# **BLOCK 8 CENTRAL PARK PROJECT**

**ACCESS REVIEW**

**FINAL v3**

22 January 2014

2 STUDIO10/1 BED - POST-ADAPTATION - TYPE 1
L2.11, L2.12

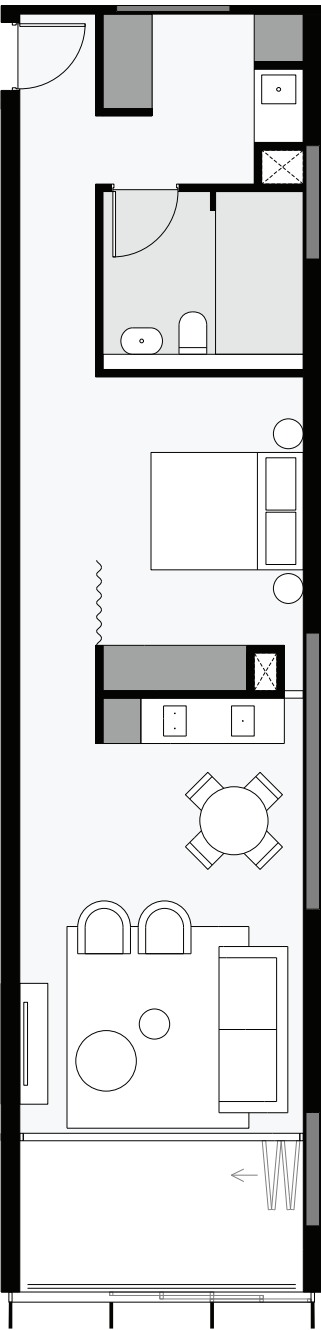
The bathroom has suitable pre-adaption dimensions to achieve the required circulation spaces at post-adaption stage. Review is required, to ensure 2300mm x 1900mm unobstructed circulation areas are provided around the toilet pan at post adaptation, which is achievable in rotating the toilet pan.

- (i) Ensure the entry door has a minimum 850mm clear opening width, compliant with AS1428.1-2009.
- (ii) Ensure the toilet pan is centred 450-460mm from the side wall at pre-adaptation, to minimise amount of modification required at post adaptation.

- (iii) Ensure the post adaptation toilet pan is provided at the same location as proposed at pre-adaptation, to ensure the toilet can achieve a minimum 2300mm x 1900mm unobstructed circulation area around the toilet pan.

- (iv) Pre-adaption drawings for bathroom to include extra capped off plumbing services for toilet and basin to allow for re- location in compliance with AS1428.1 at post adaption stage. In addition continuous water-proofing/tiling is to be provided behind joinery for ease of removal and adaption.

- (v) Ensure there is no hob into the shower, to achieve a minimum 900mm x 1250mm unobstructed clearance in front of the toilet pan at pre-adaptation, as required for the provision of a visitable toilet.

- (vi) Provide a minimum 800mm workspace beside cooktop, sink and small set-down area near fridge compliant with AS4299 at pre-adaption stage or ensure this is easily achievable (at post-adaption) without replacing bench-top.

1 STUDIO/1 BED - PRE ADAPTATION - TYPE 2
L03-07.12

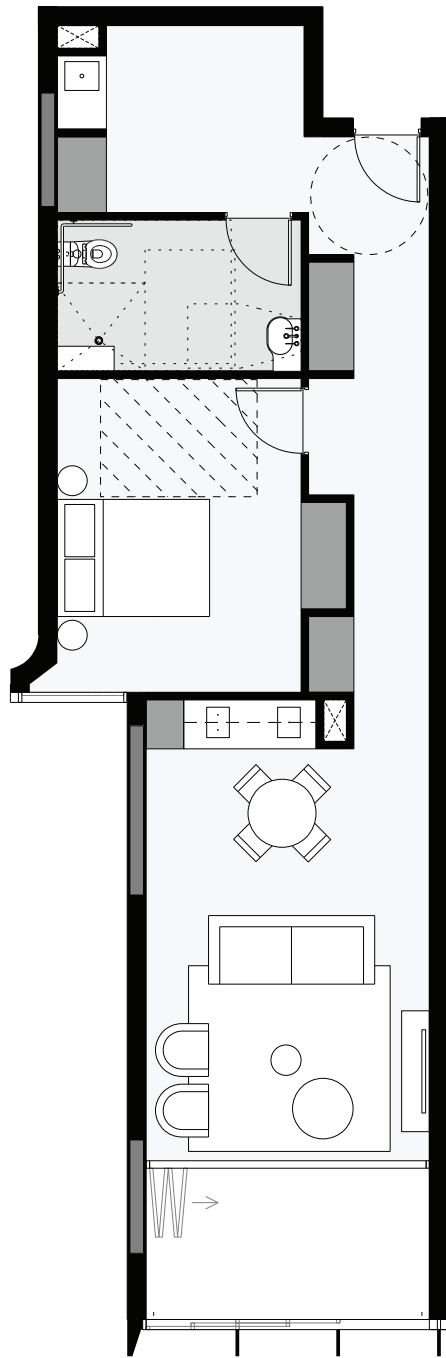
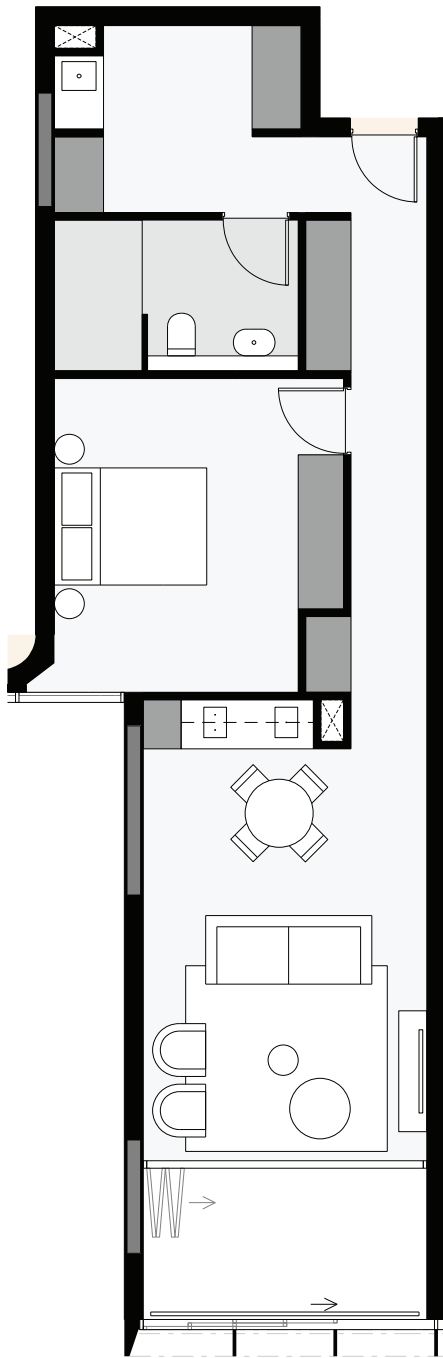
Review is required, to ensure the door has a minimum 850mm clear opening width and sufficient 340mm external latch side clearance, to allow for suitable side approach for wheelchair users to access the unit. The internal door circulation space can be achieved by removal of joinery unit in front of the door, compliant with AS4299.

- (i) Ensure the entry door has a minimum 850mm clear opening width and minimum 340mm external latch side clearance, compliant with AS1429.1-2009.
- (ii) All joinery/walls proposed to be removed at post-adaption to have continuous flooring under and be free of all services from the outset, compliant with AS4299 and AS1428.1-2009.

- (iii) Pre-adaption drawings for bathroom to include extra capped off plumbing services for toilet and basin to allow for re-location in compliance with AS1428.1 at post adaption stage. In addition continuous water-proofing/tiling is to be provided behind joinery for ease of removal and adaption.

- (iv) Ensure there is no nib wall in front of the toilet and a hob into the shower, to achieve a minimum 900mm x 1250mm unobstructed clearance in front of the toilet pan at pre-adaptation, as required for the provision of a visitable toilet.

- (v) Provide a minimum 800mm workspace beside cooktop, sink and small set-down area near fridge compliant with AS4299 at pre-adaption stage or ensure this is easily achievable (at post-adaption) without replacing bench-top.

1 STUDIO/ 1 BED - PRE ADAPTATION - TYPE 2
L03-07.13

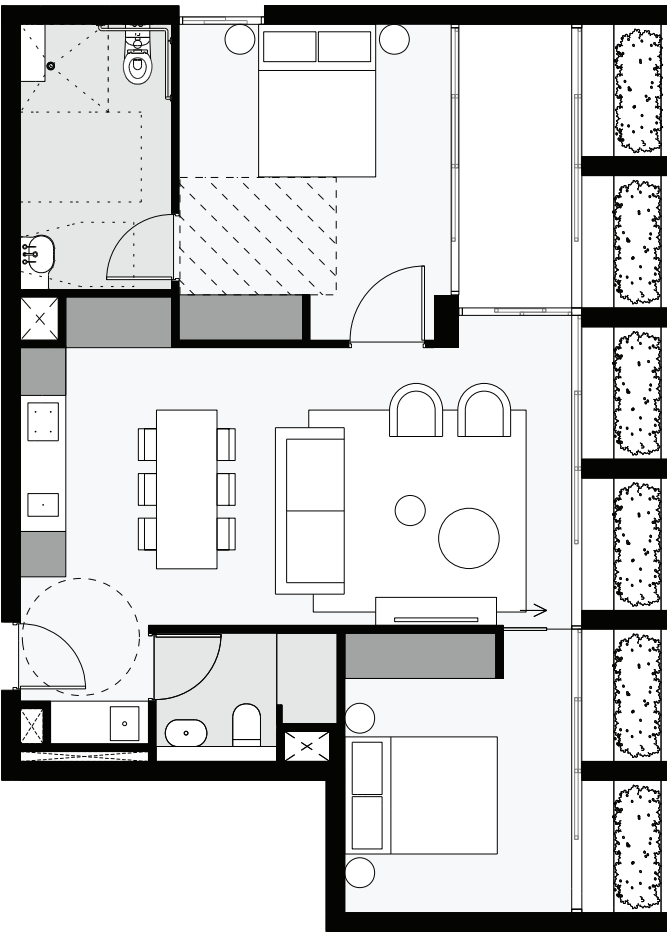
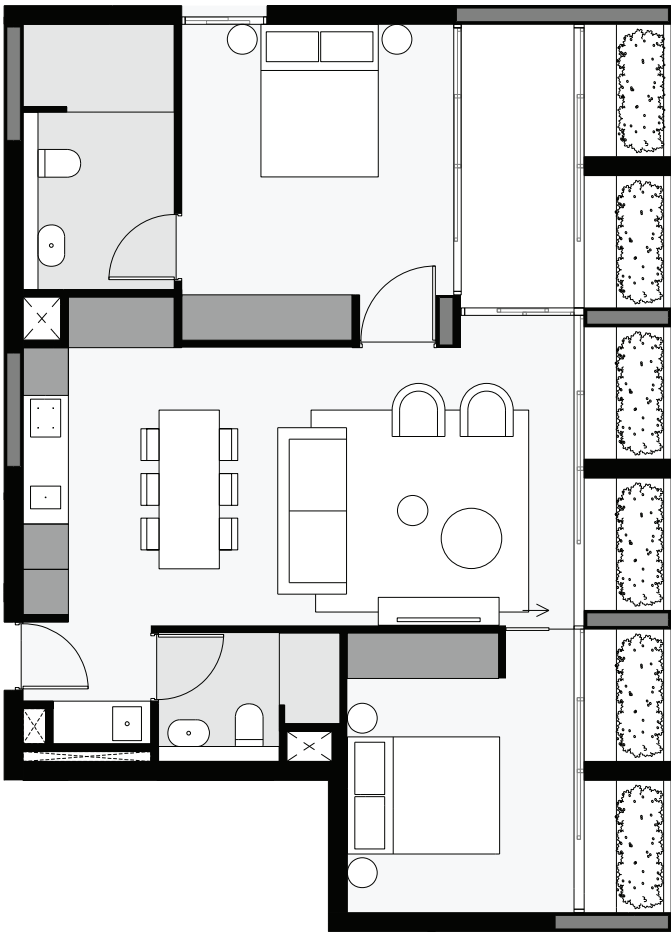
Review is required, to ensure the door has a minimum 850mm clear opening width and sufficient 510mm external latch side clearance, to allow for suitable side approach for wheelchair users to access the unit. The internal door circulation space can be achieved by removal of joinery unit in front of the door, compliant with AS4299.

- (i) Ensure the entry door has a minimum 850mm clear opening width and minimum 510mm external latch side clearance, compliant with AS1429.1-2009.
- (ii) All joinery/walls proposed to be removed at post-adaption to have continuous flooring under and be free of all services from the outset, compliant with AS4299 and AS1428.1-2009.

- (iii) Pre-adaption drawings for bathroom to include extra capped off plumbing services for toilet and basin to allow for re- location in compliance with AS1428.1 at post adaption stage. In addition continuous water-proofing/tiling is to be provided behind joinery for ease of removal and adaption.

- (iv) Provide a minimum 800mm workspace beside cooktop, sink and small set-down area near fridge compliant with AS4299 at pre-adaption stage or ensure this is easily achievable (at post-adaption) without replacing bench-top.

3 2 BED - PRE-ADAPTATION - TYPE 2
L00.01

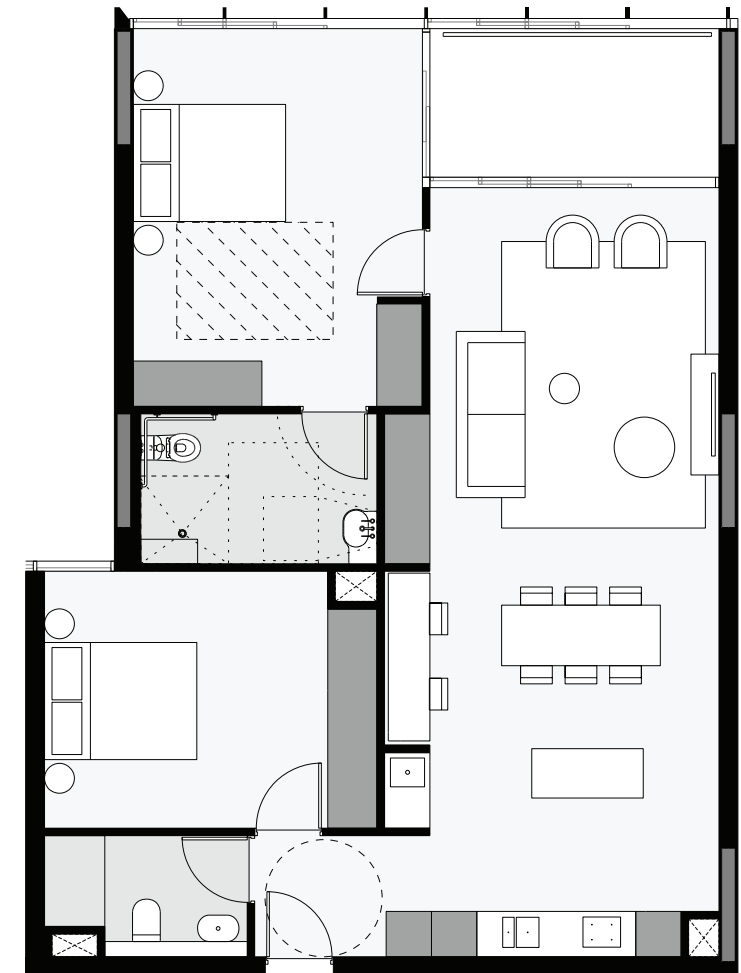
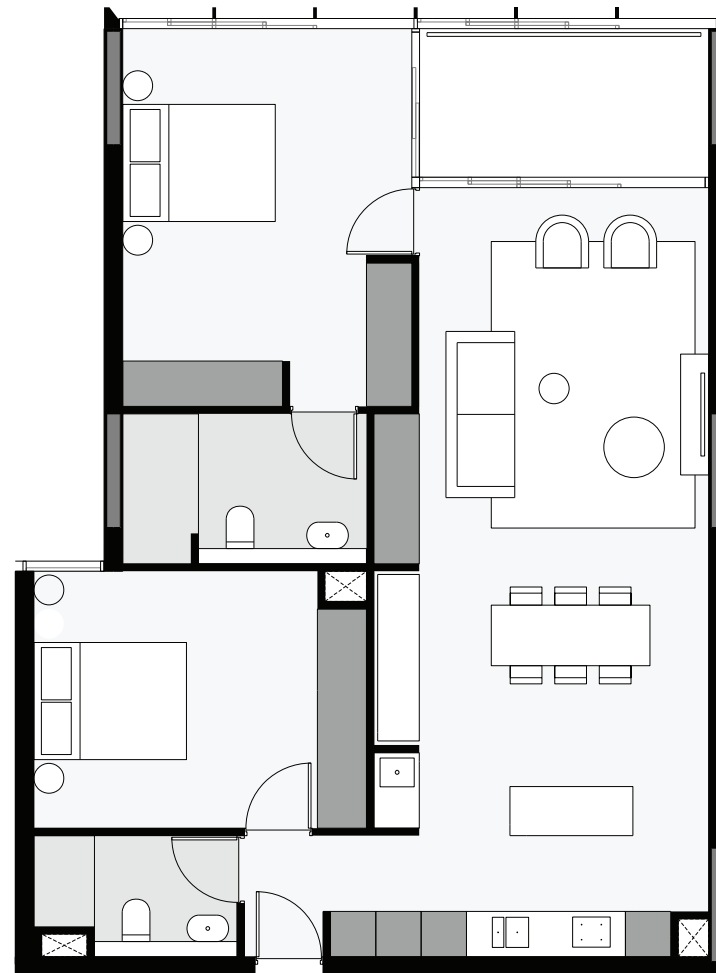
The entry door of the adaptable unit appears to have suitable external door circulation space and internal door circulation space can be easily achieved by removal of joinery unit beside door, compliant with AS4299. Review is required, to ensure the door has a minimum 850mm clear opening width, compliant with AS1428.1-2009.

- (i) Ensure the entry door has a minimum 850mm clear opening width and a minimum 340mm external latch side clearance, compliant with AS1428.1-2009.
- (ii) Pre-adaption drawings for bathroom to include extra capped off plumbing services for toilet to allow for re- location in compliance with AS1428.1 at post adaption stage. In addition continuous water-proofing/tiling is to be provided behind joinery for ease of removal and adaption.
- (iii) Provide a minimum 800mm workspace beside cooktop and a 300mm bench-top adjacent refrigerator, compliant with AS4299 at pre-adaption or ensure this is easily achievable (at post-adaption) without replacing bench-top.
- (iv) Provide slip-resistant floor surface with minimum wet pendulum test rating of 'X' (under HB197/AS4856) in kitchen, laundry and adaptable bathroom at pre-adaption as required by AS4299 clause 4.5.4.

3 2 BED - POST-ADAPTATION - TYPE 3
L10-11.01, L10-11.02

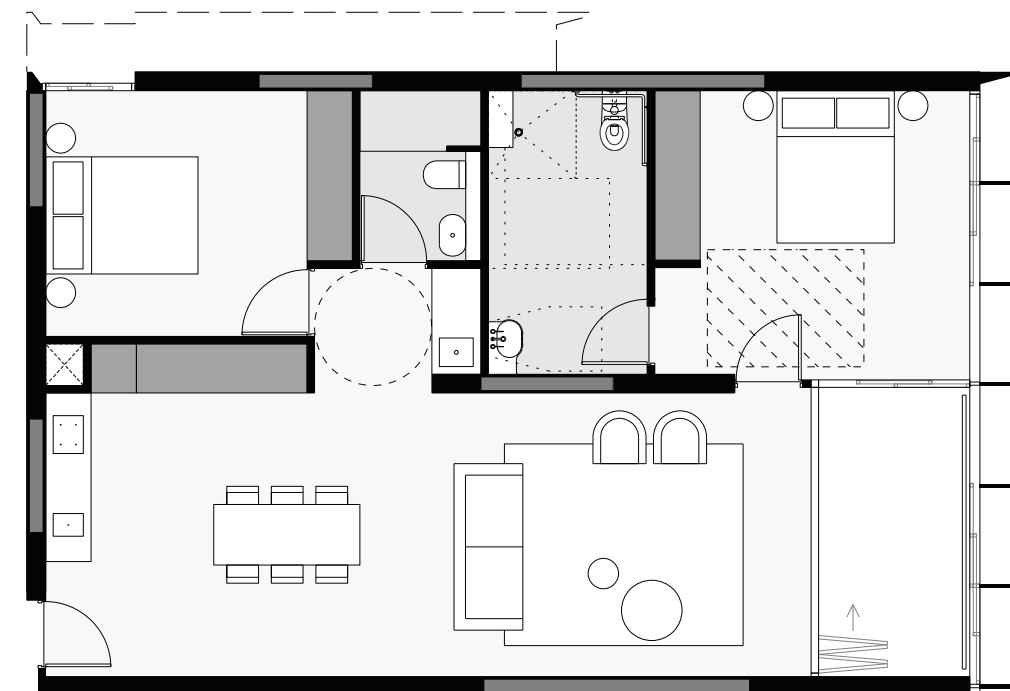
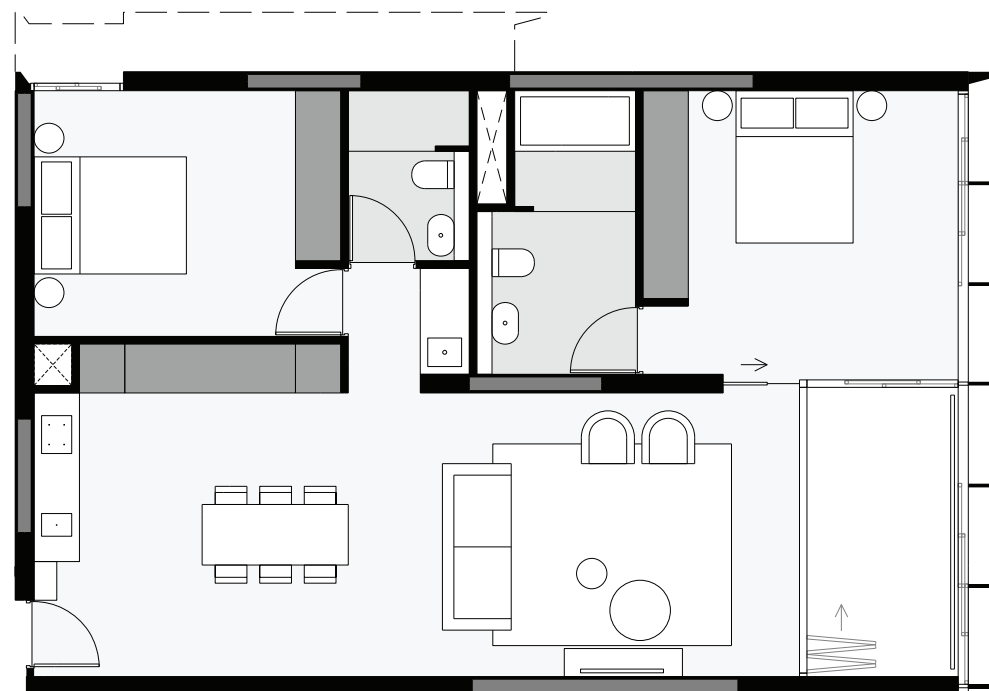
The unit entry door appears to have suitable external length and latch side circulation areas. The internal door circulation space can be easily achieved by removal of joinery unit beside the door, compliant with AS4299. Review is required, to ensure the door has a minimum 850mm clear opening width, compliant with AS1428.1-2009.

- (i) Ensure the entry door has a minimum 850mm clear opening width, compliant with AS1428.1-2009.
- (ii) Ensure the corridor leading to the unit entry door has a minimum 1240mm clear width, to allow for sufficient external depth and latch side door circulation areas, compliant with AS1428.1-2009.

- (iii) All joinery/walls proposed to be removed at post-adaption to have continuous flooring under and be free of all services from the outset, compliant with AS4299 and AS1428.1-2009.

- (iv) Pre-adaption drawings for bathroom to include extra capped off plumbing services for toilet and basin to allow for re- location in compliance with AS1428.1 at post adaption stage.

- (v) Provide a minimum 800mm workspace beside cooktop and a 300mm bench-top adjacent refrigerator, compliant with AS4299 at pre-adaption or ensure this is easily achievable (at post-adaption) without replacing bench-top.
